WSCC COUNTY HIGHWAYS CONSULTATION RESPONSE - REVISED

The proposal is to create 12 residential flats, a mix of 2 studio flats, 9 x 1-bedroom flats and 1 x 2 bedroom flat. The development does not provide any car parking but it is a 4-minute walk to the train station, and local bus stops. Cycle storage will be provided for the flats with a cycle store located at ground level within the building. No objection is raised subject to any conditions attached.

Potential for
additional bays
on-street

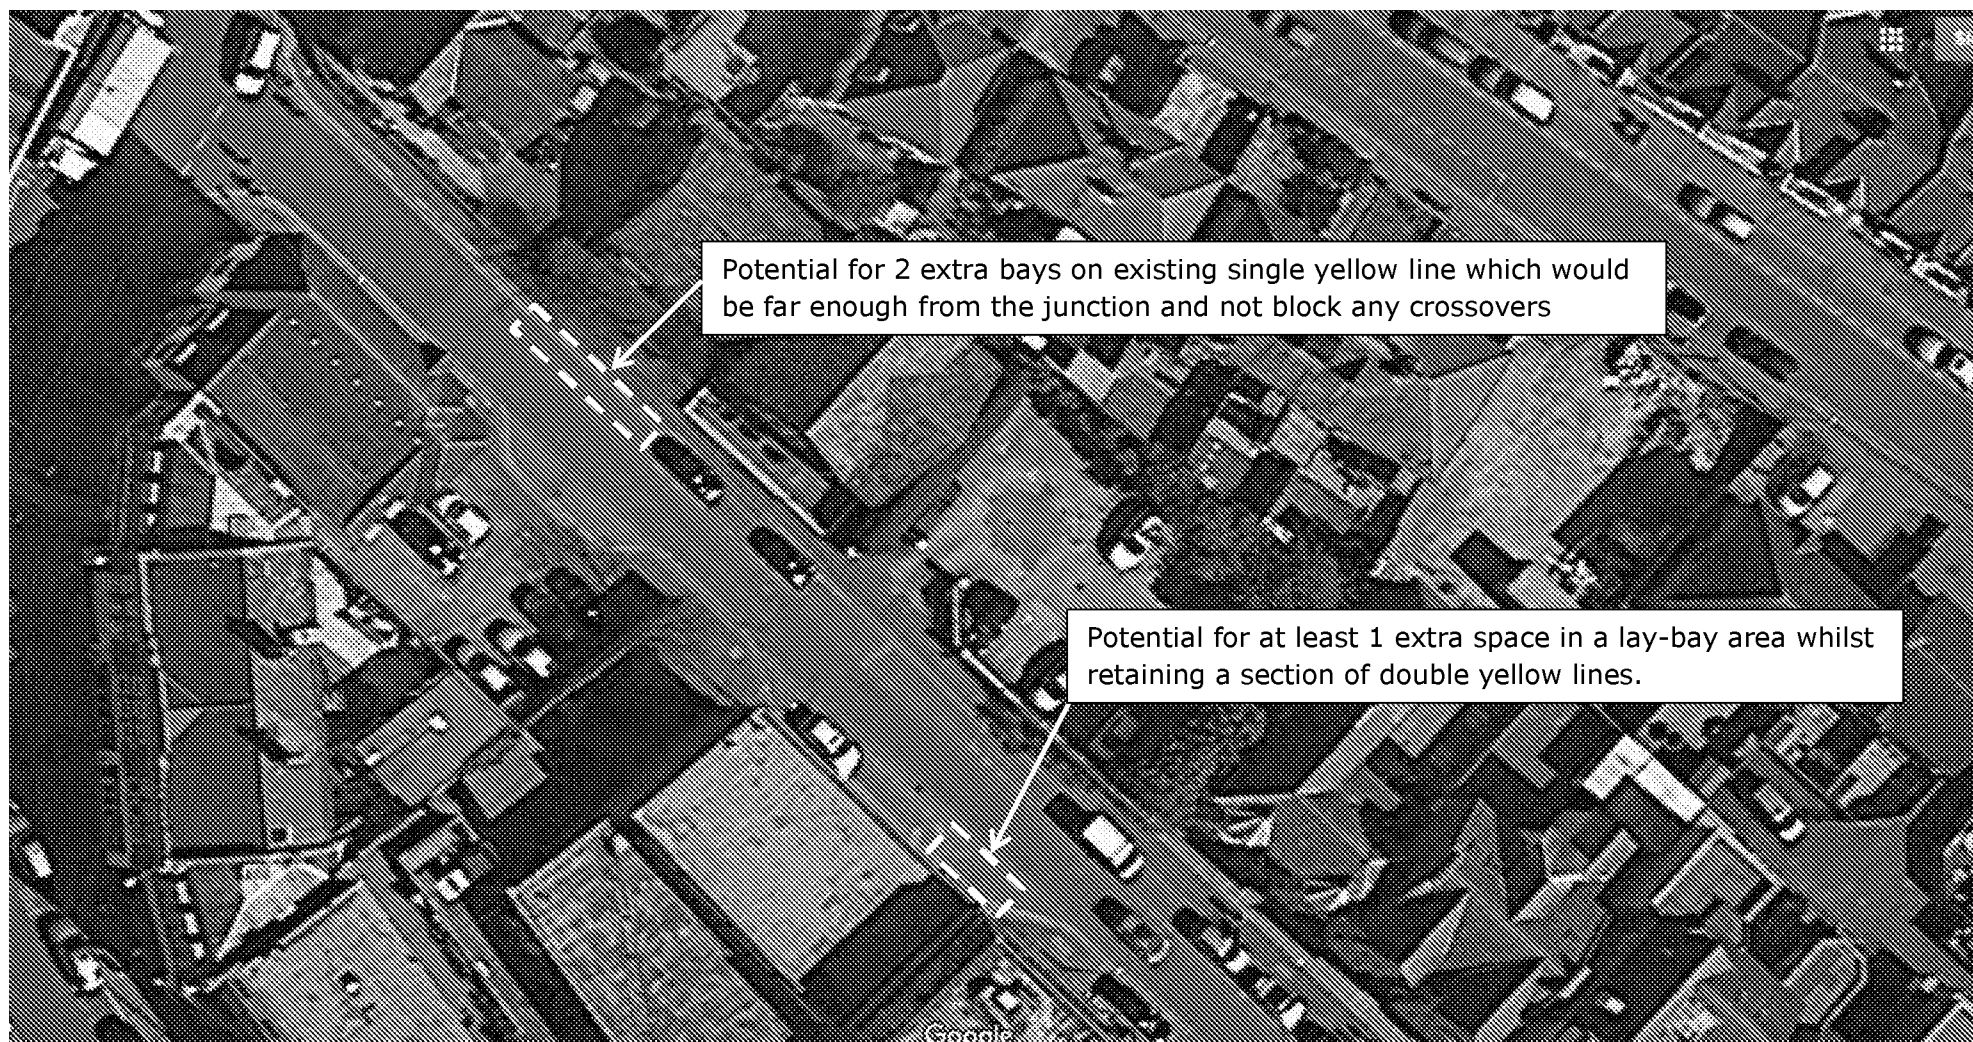
The survey has identified the possibility to convert some pay and display spaces into permit holder bays, and 3 locations along Sudley Road have also been suggested. These will need to be discussed further with the Parking Team and any off-site works funded by the applicant as part of a s106 agreement, including any TRO's associated with the parking spaces created.

It is noticed the suggested new parking space which is proposed outside the Recital Hall may cause issues for vehicles wishing to enter or exit the servicing area (currently the site compound area). Clarification needs to be sought over the proposed use of this area and the size of vehicles using this to ensure any new car parking doesn't restrict movements in and out. If this will be used by larger vehicles swept path diagrams will be required to show how the proposed spaces may affect the use of this servicing area. In the first instance the applicant would need to contact the Parking Team Manager to identify the process involved to progress the proposal.
